Condition 3.

Hennock International Ltd

Drain installation
details.

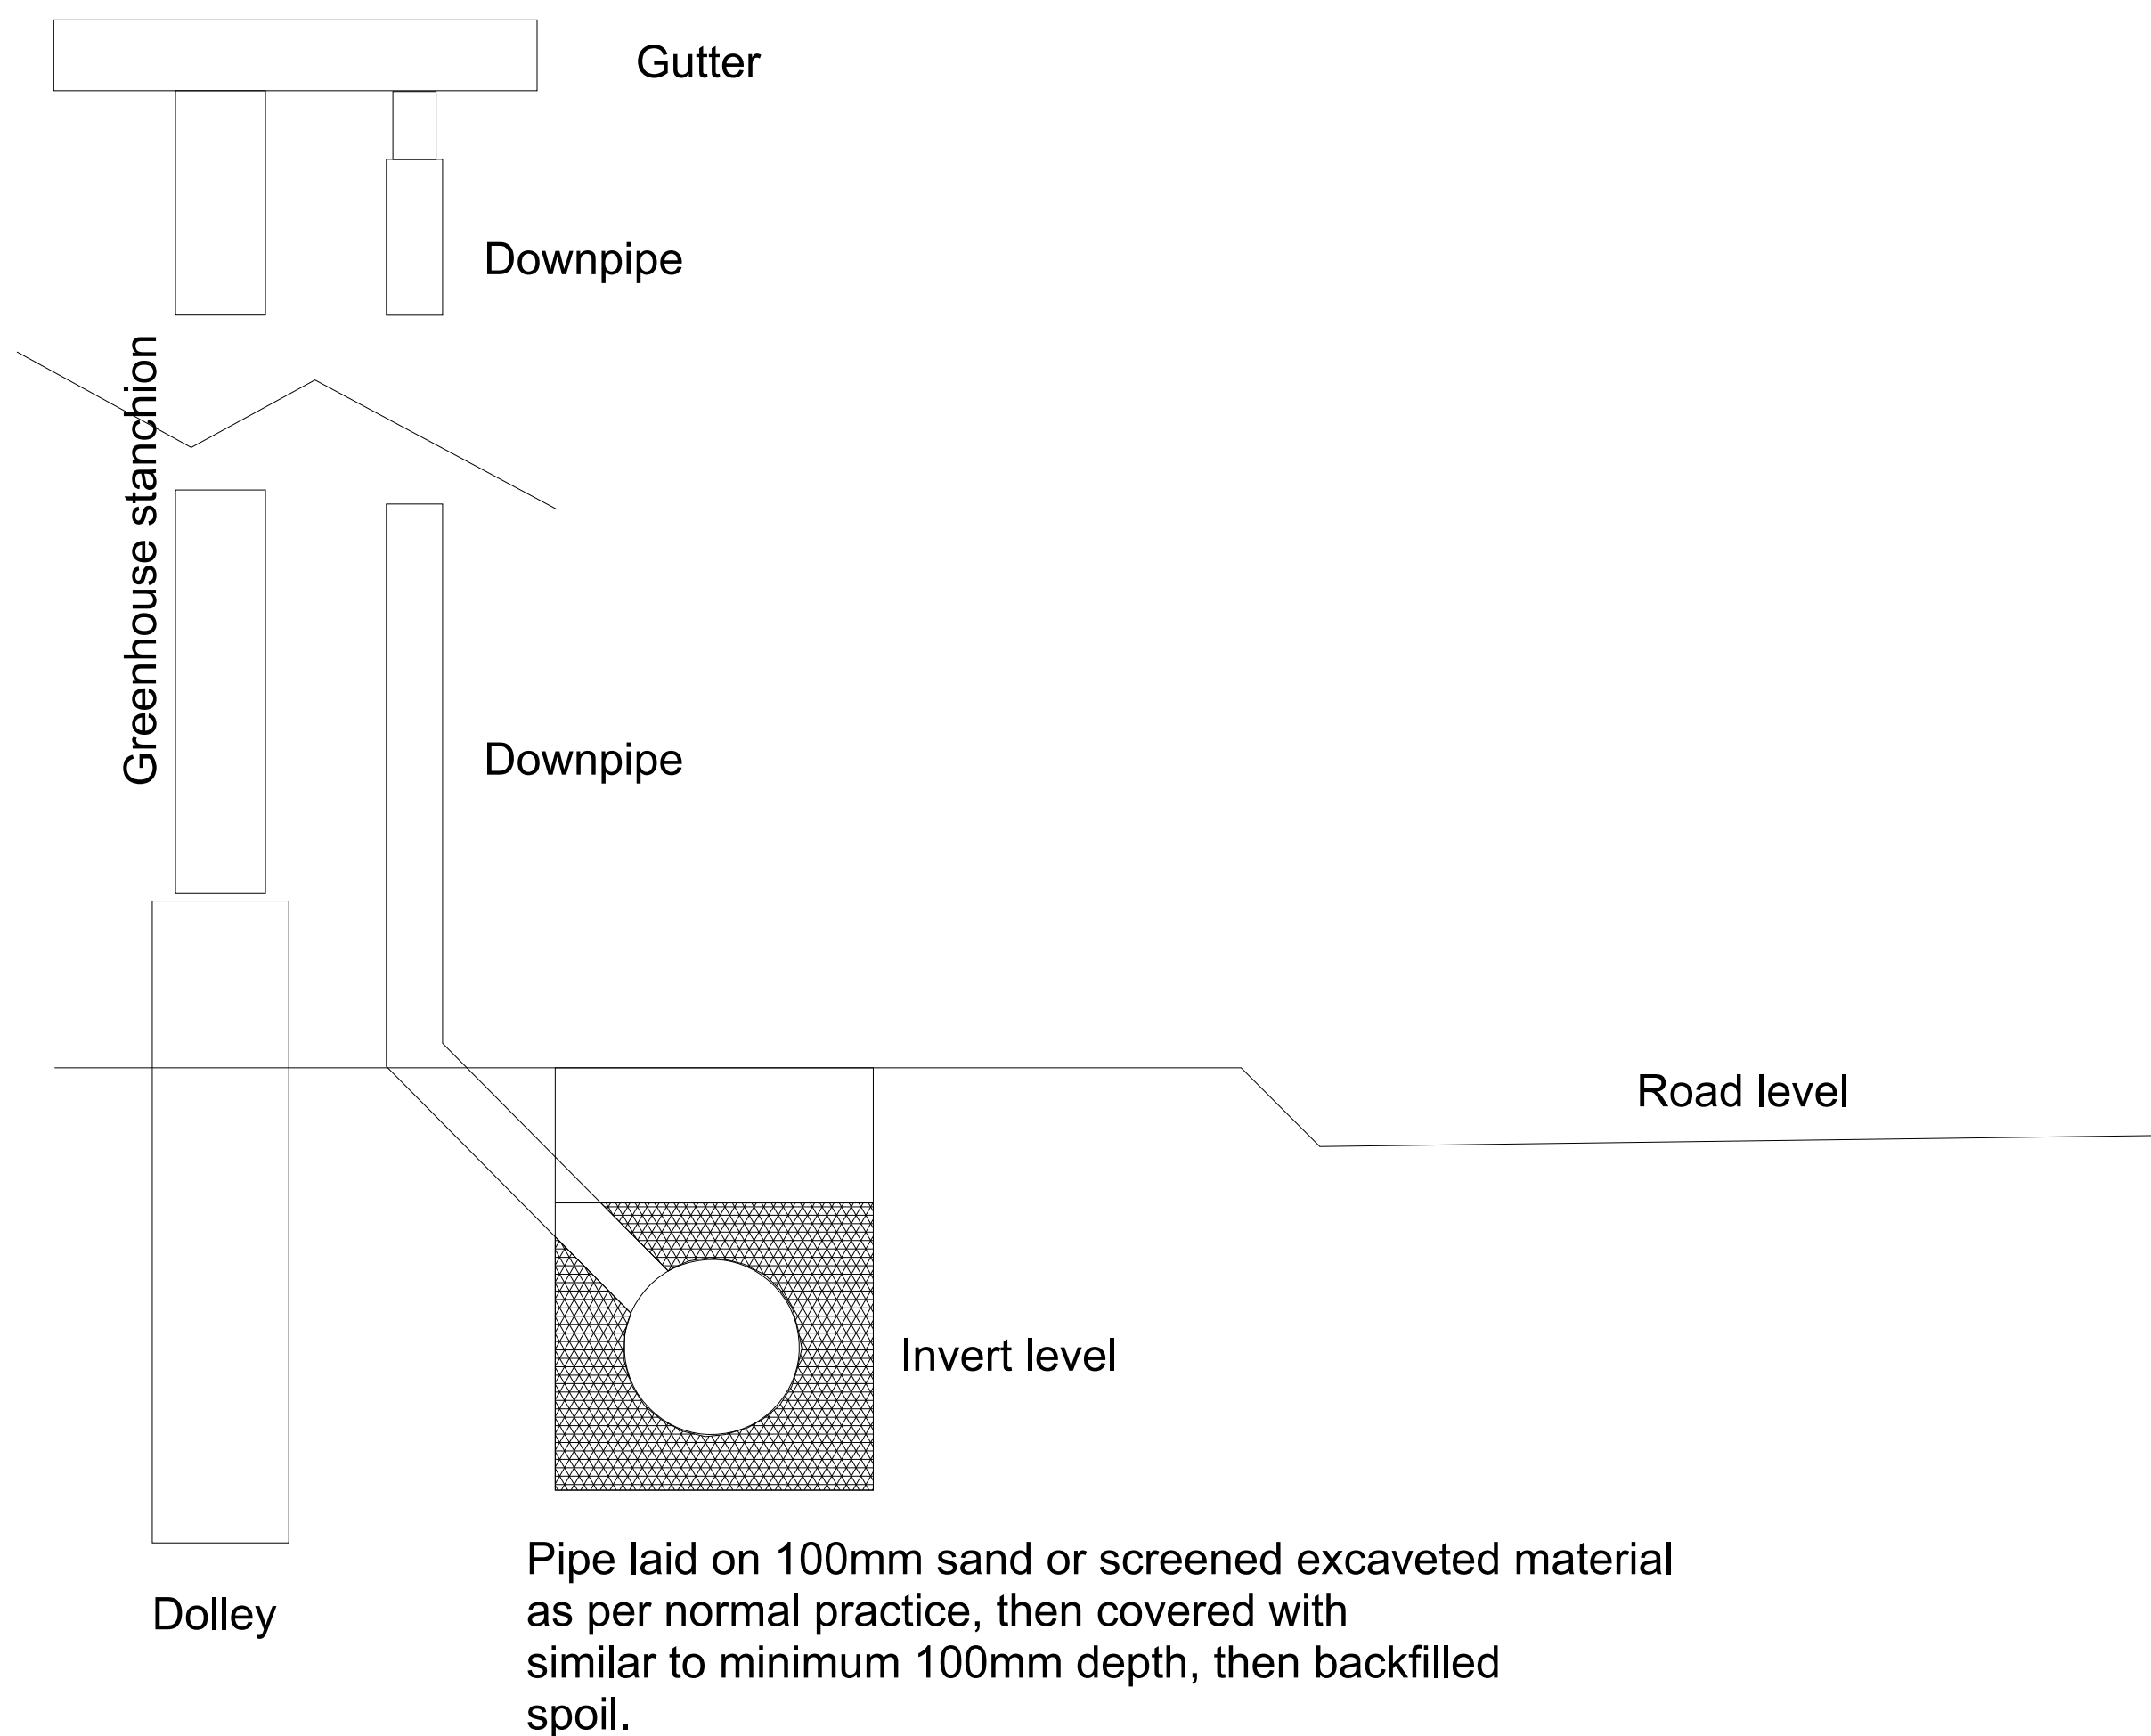
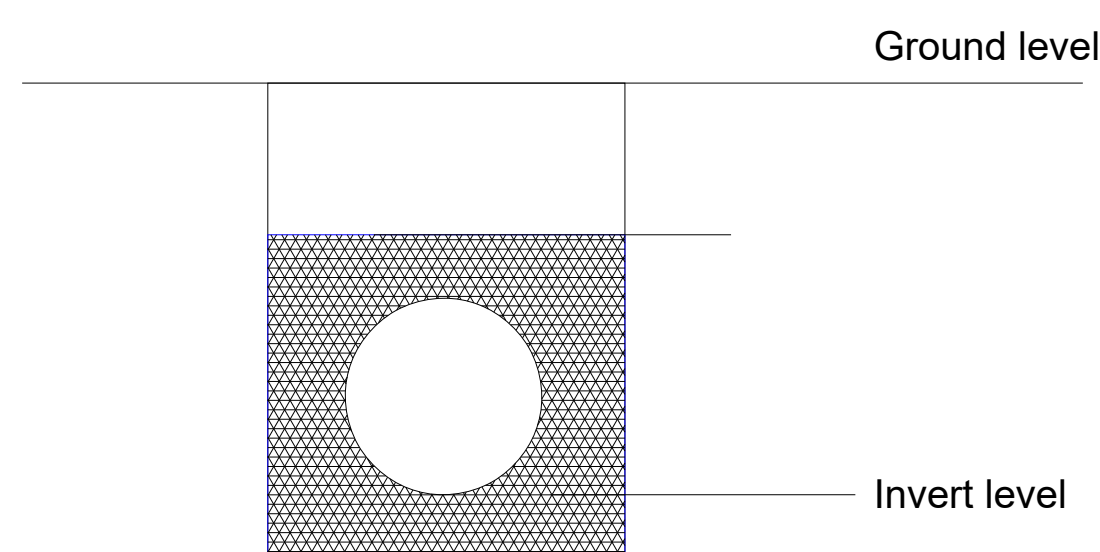
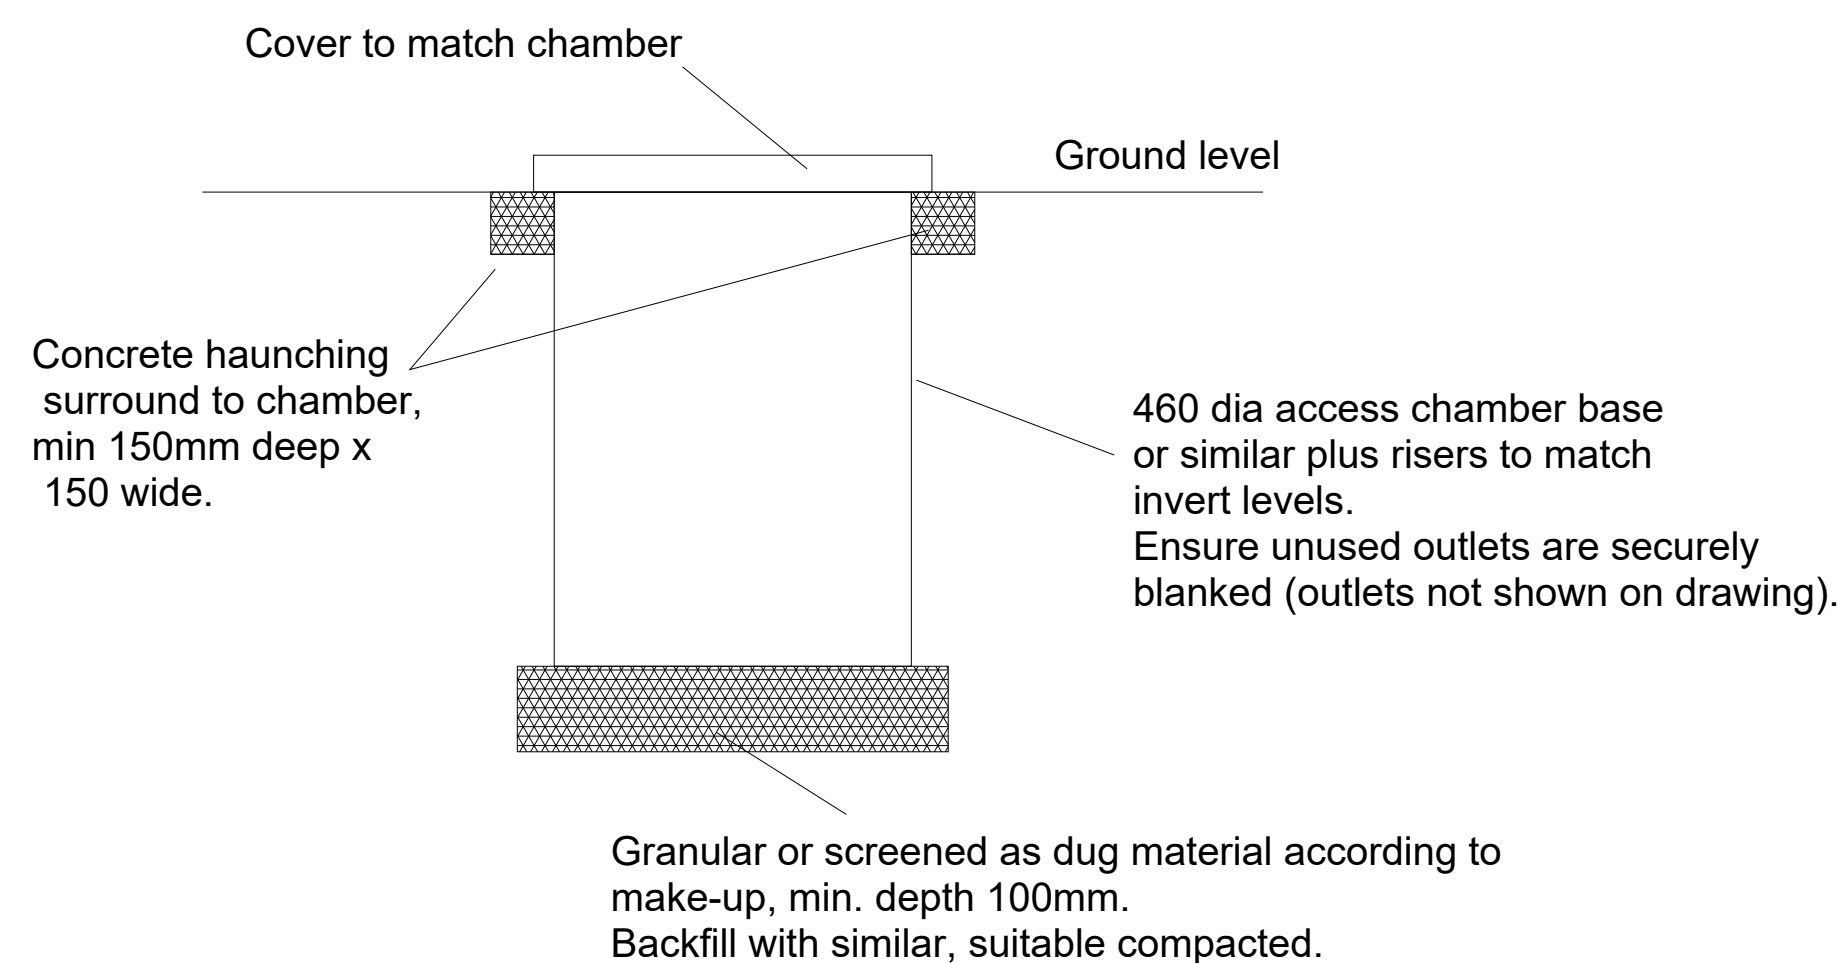
See also "Drain installation details" drawing.
